WEST SUSSEX COUNTY COUNCIL CONSULTATION

TO:	<u>Arun</u> District Council <u>FAO:</u> Simon Davis
FROM:	<u>WSCC</u> - Highways Authority: Tim Townsend
DATE:	26 September 2019
LOCATION:	Bridge Cottage <u>Lidsey</u> Road <u>Bognor</u> Regis <u>PO22 9PH</u>
SUBJECT:	AL/75/19/PL Construction of 8 no. dwellings, alterations to access and associated works - This is a Departure from the Development Plan.
DATE OF SITE VISIT:	30 th May and 4 th June 2018 (for previous planning application AL/20/18/OUT)
RECOMMENDATION:	<u>Objection</u>
S106 CONTRIBUTION TOTAL:	£ (comments to be sent separately other than where specified)

FIGURE-1.3

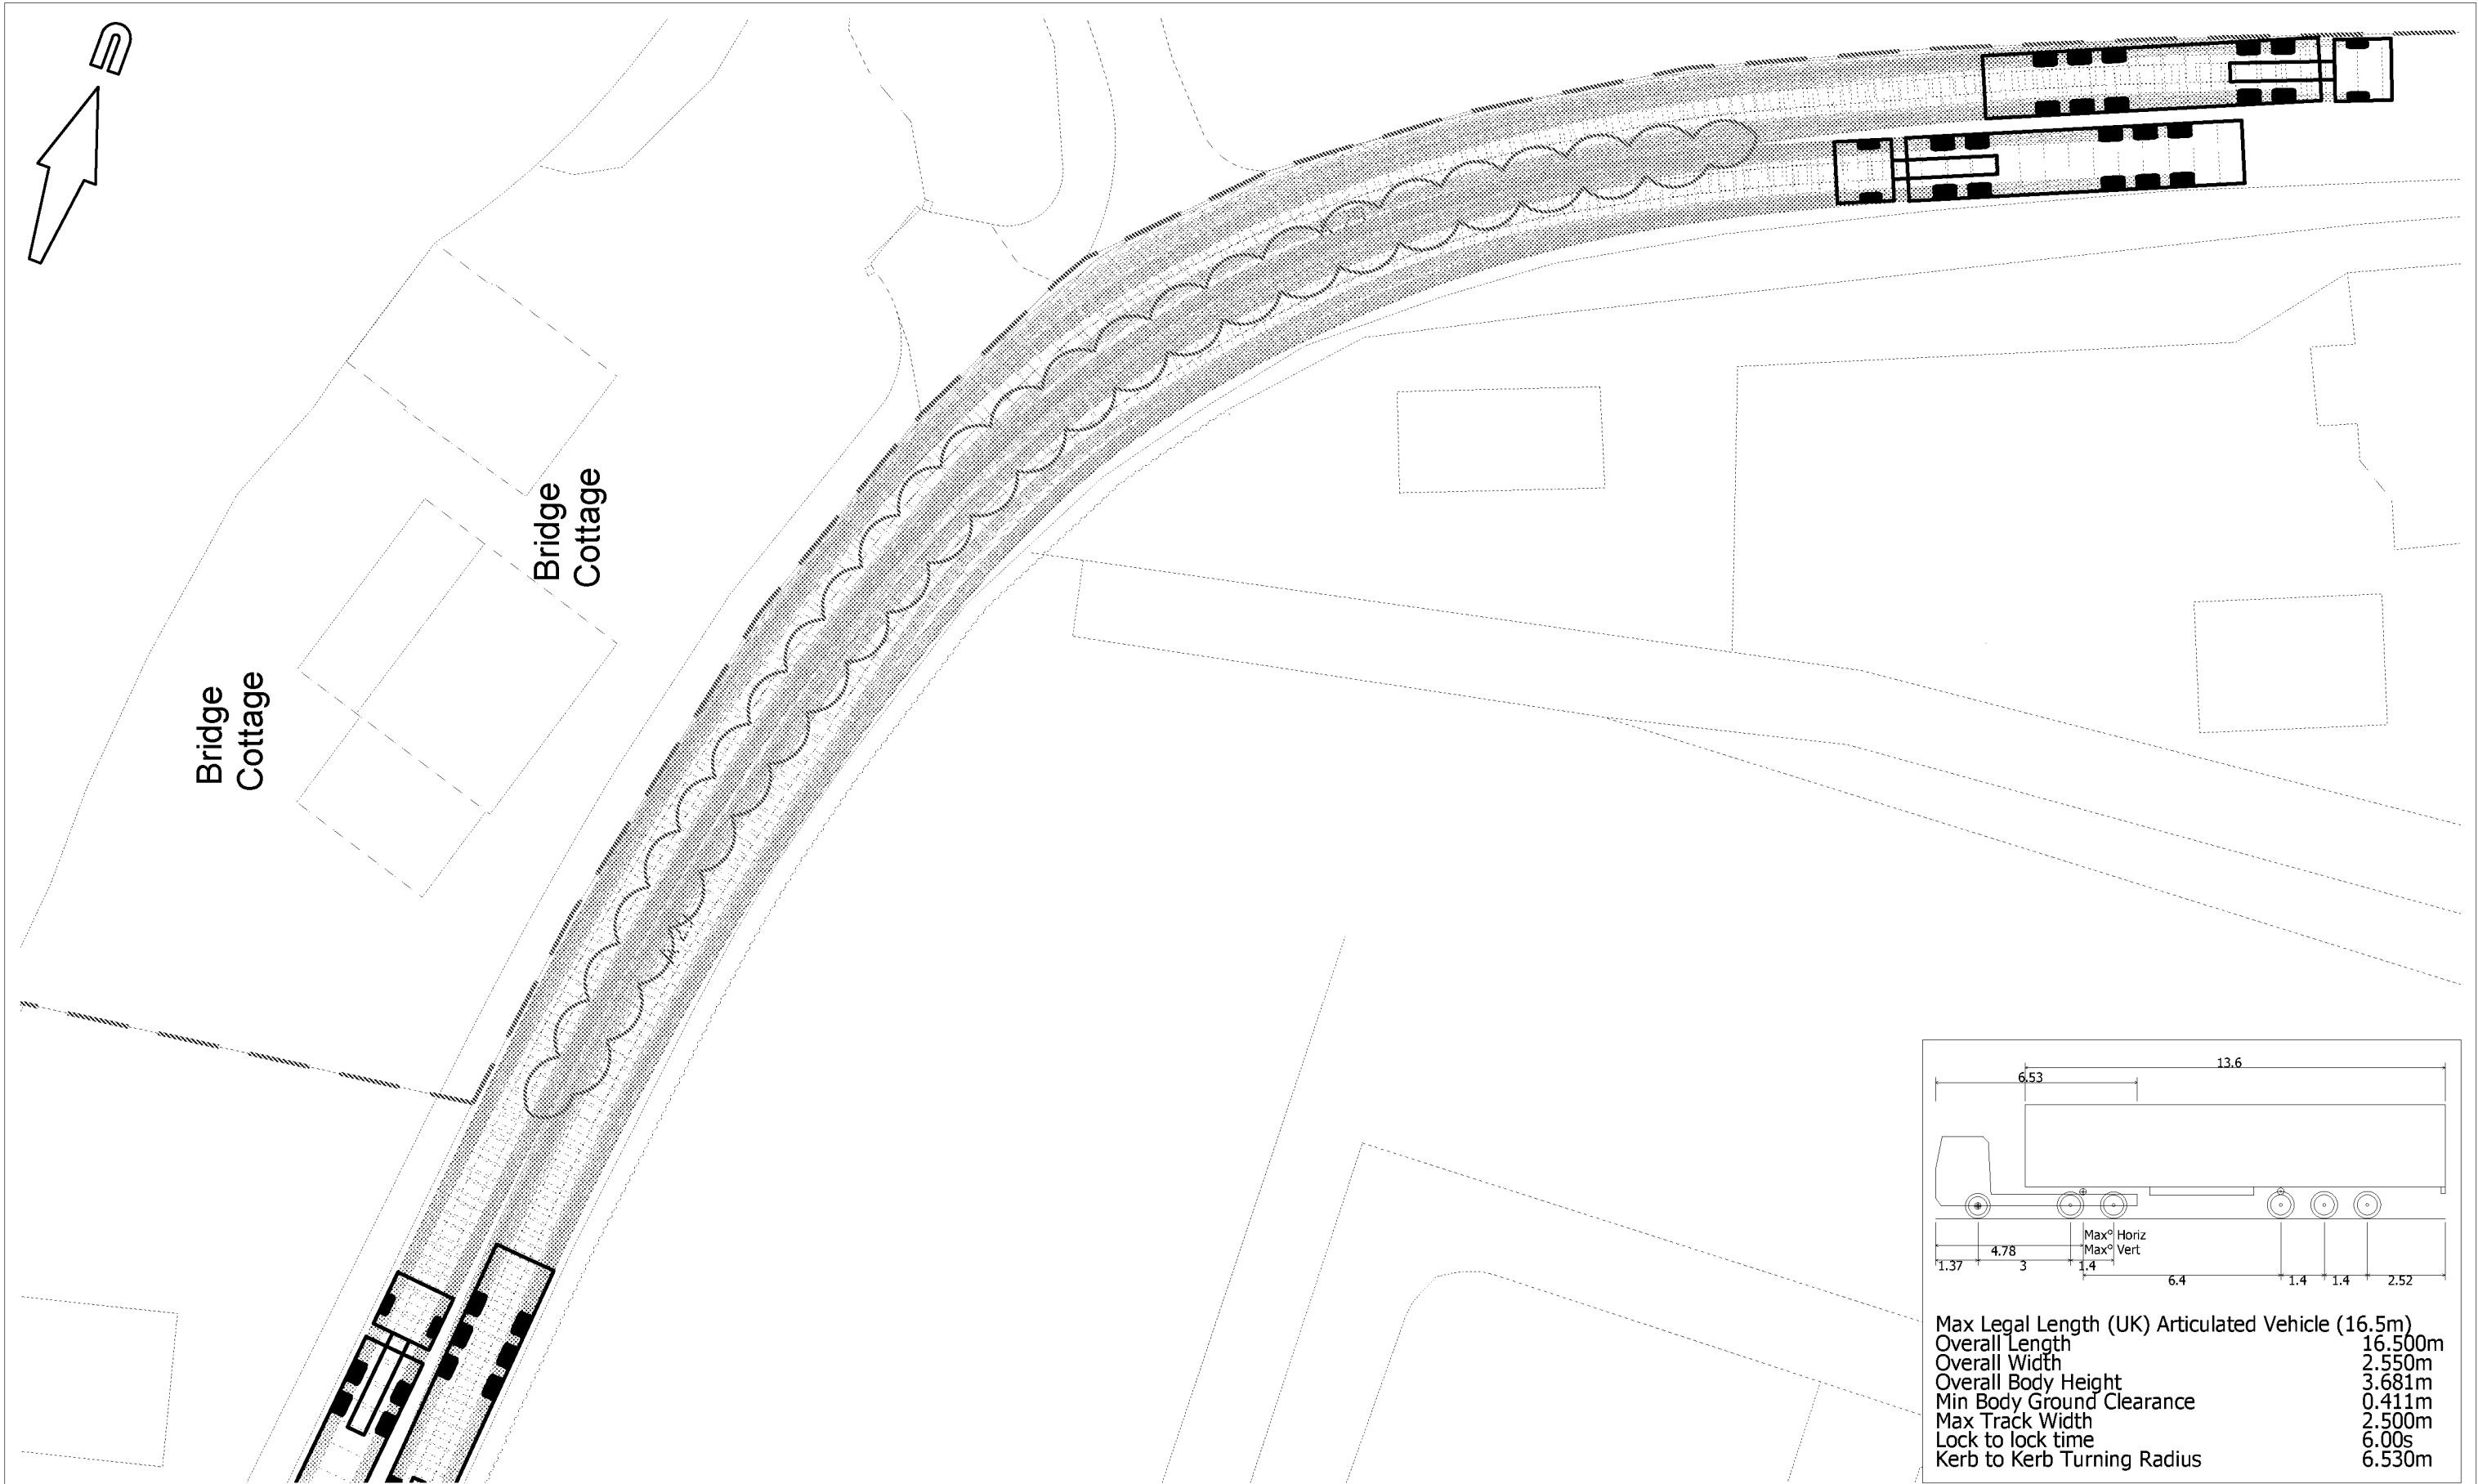
These are provided in Figures (drawings) 1.3, 1.4, 1.7 and 1.8. Figure 1.8 shows the track of two 16.5m articulated vehicles passing one-another on the apex of the bend on the A29 post-road widening as proposed as part of the planning application. Figures 1.3 and 1.4 show the tracking of a 9.860m refuse vehicles within the site and entering the site from the A29. However, neither plan shows the same vehicle emerging. Also, the drawings are based on a specific length vehicle. The applicant should check with Arun DC what length of vehicle would use the site. Current information on Arun DC website suggests 10.22m but further information obtained through discussion with officers about a nearby site suggests it might be a longer vehicle required to use it. Any change to that already shown should be 'tracked' and revised drawings provided to the LPA and CHA (including exit back to A29).
